East Anglia One North (EA1N) and East Anglia Two (EA2) Offshore Wind Farms

Planning Inspectorate Reference: EA1N – EN010077, EA2 – EN010078

Deadline 2 - 17 November 2020

Comments of Suffolk County Council as Highways Authority

TITLE
 SWEEP PATH ANALYSIS
 A1094/B1122 ROUNDABOUT

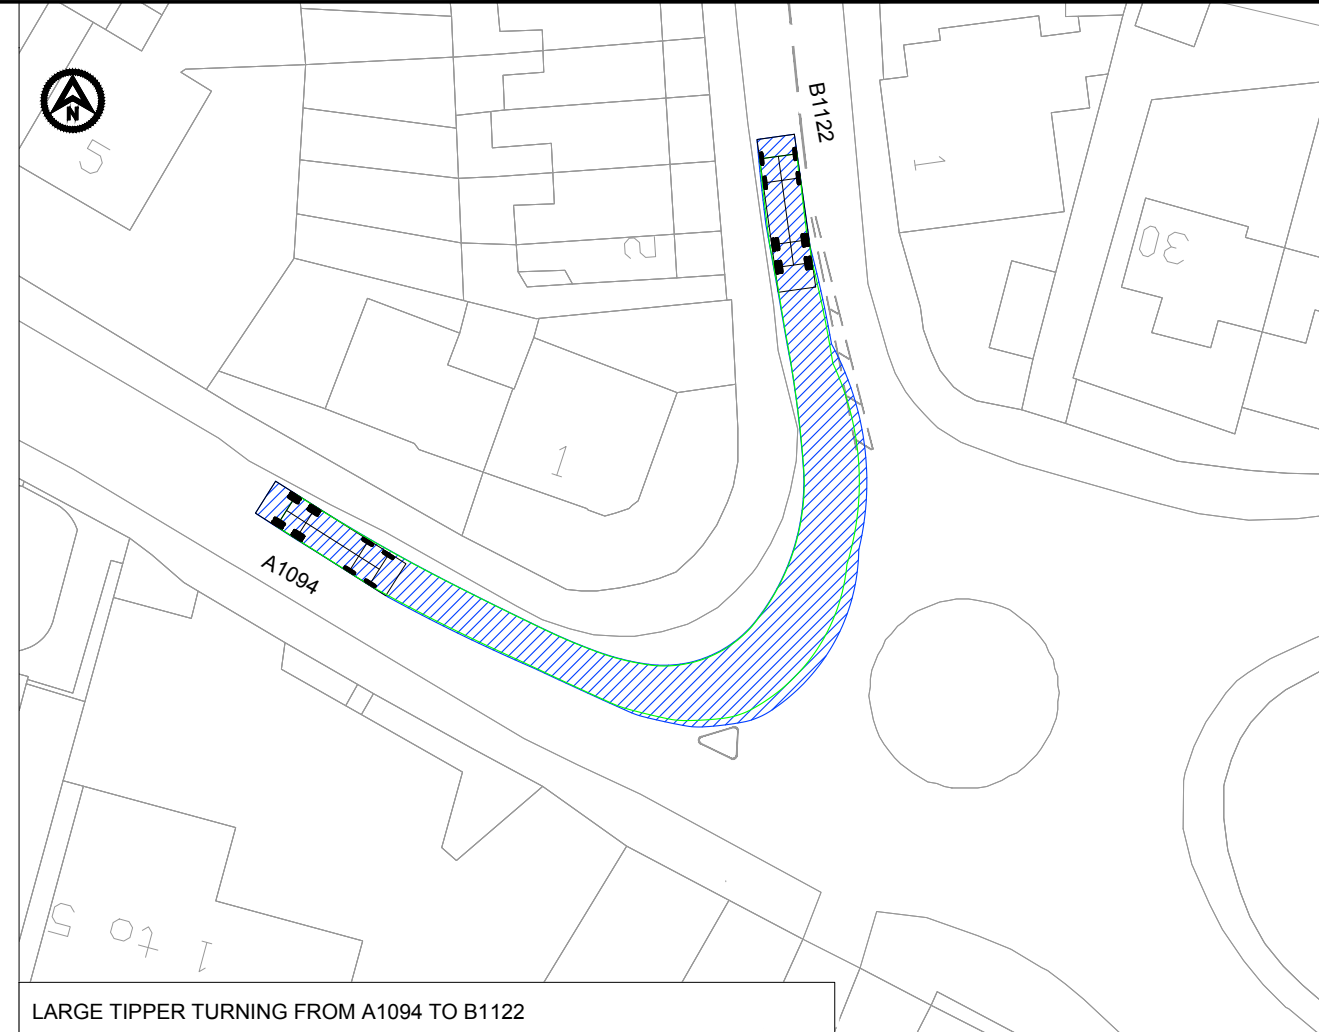
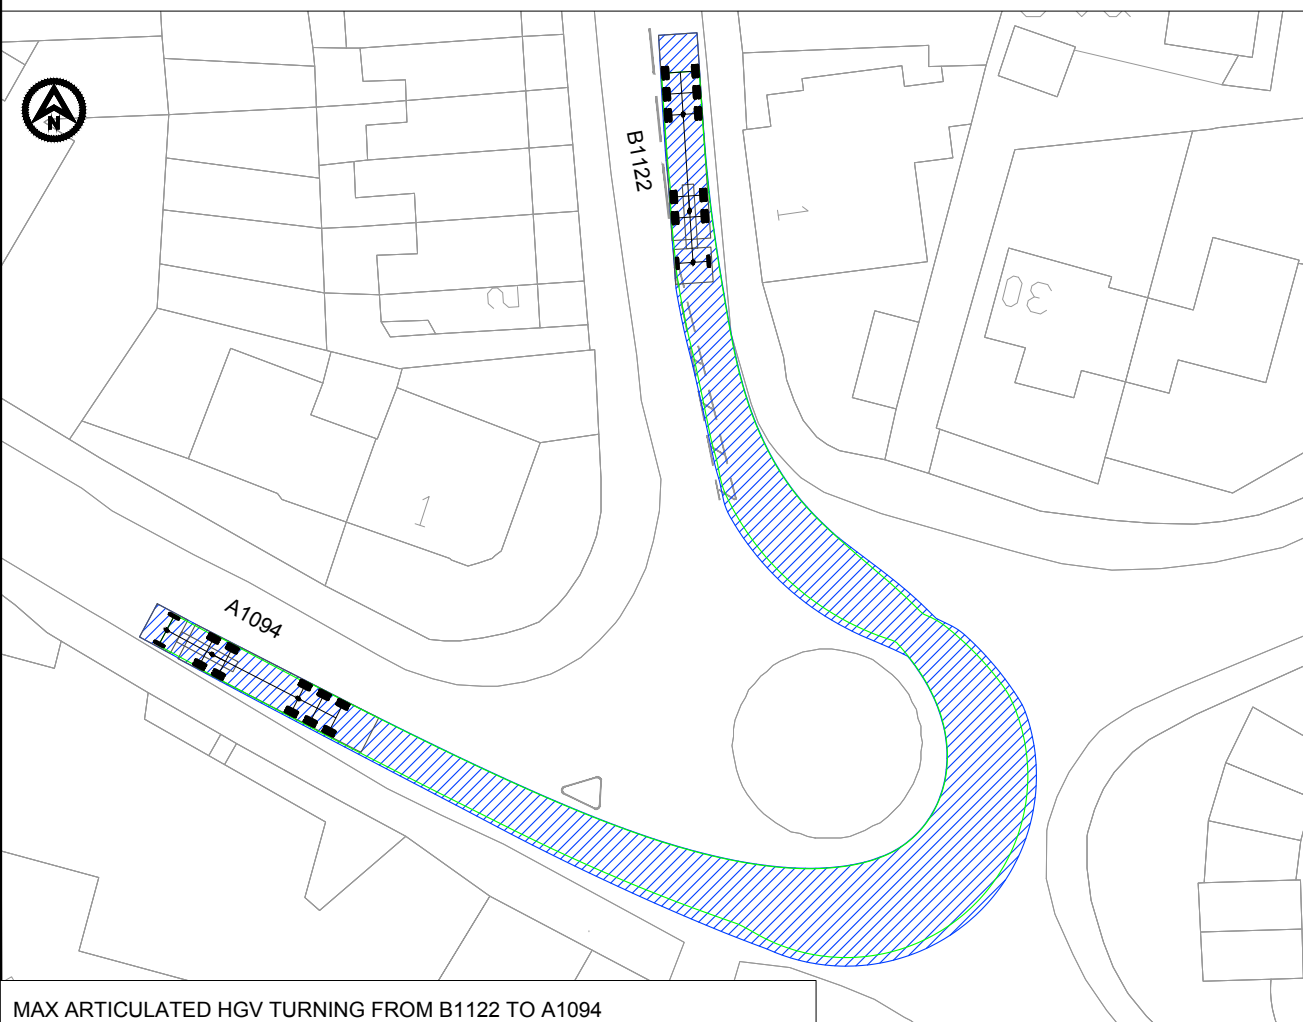
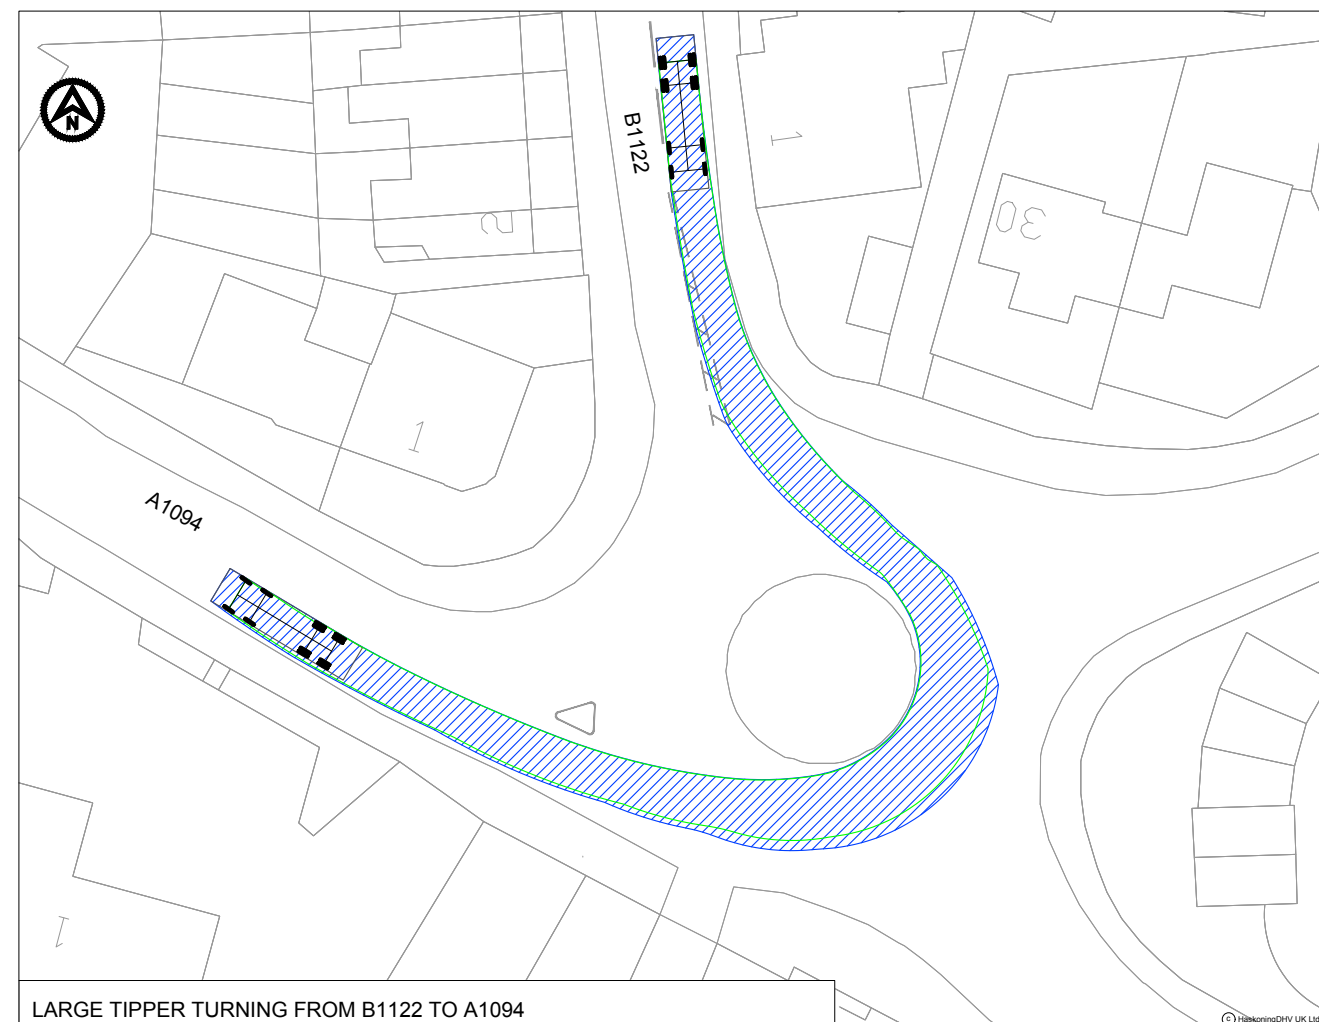
1.18.51		<p>Paragraph 330 refers to the use of a pilot vehicle for larger articulated vehicles heading for accesses 5 and 6. Please explain how the use of a pilot vehicle would reduce driver delay at the A1094/B1122 roundabout junction such that it can be relied upon as mitigation.</p>		<p>The swept path analysis presented within Appendix 26.21 (APP—547) demonstrates that an articulated HGV would oversail into the opposite lane when turning from the A1094 onto the B1122. If this lane was</p>	<p>SCC understands that the driver of any pilot vehicle will require the appropriate legal powers to stop vehicles. This should be confirmed with Suffolk Constabulary.</p>

<p>blocked by an oncoming vehicle the HGV would not be able to make the manoeuvre. The HGV or oncoming driver, may therefore have to reverse which may not be possible with following traffic, leading to driver delay. A pilot vehicle would run ahead of the vehicle it is escorting. At the junction of the A1094 and B1122, the pilot vehicle would stop any oncoming traffic to allow the following HGV to pass any oncoming traffic.</p>
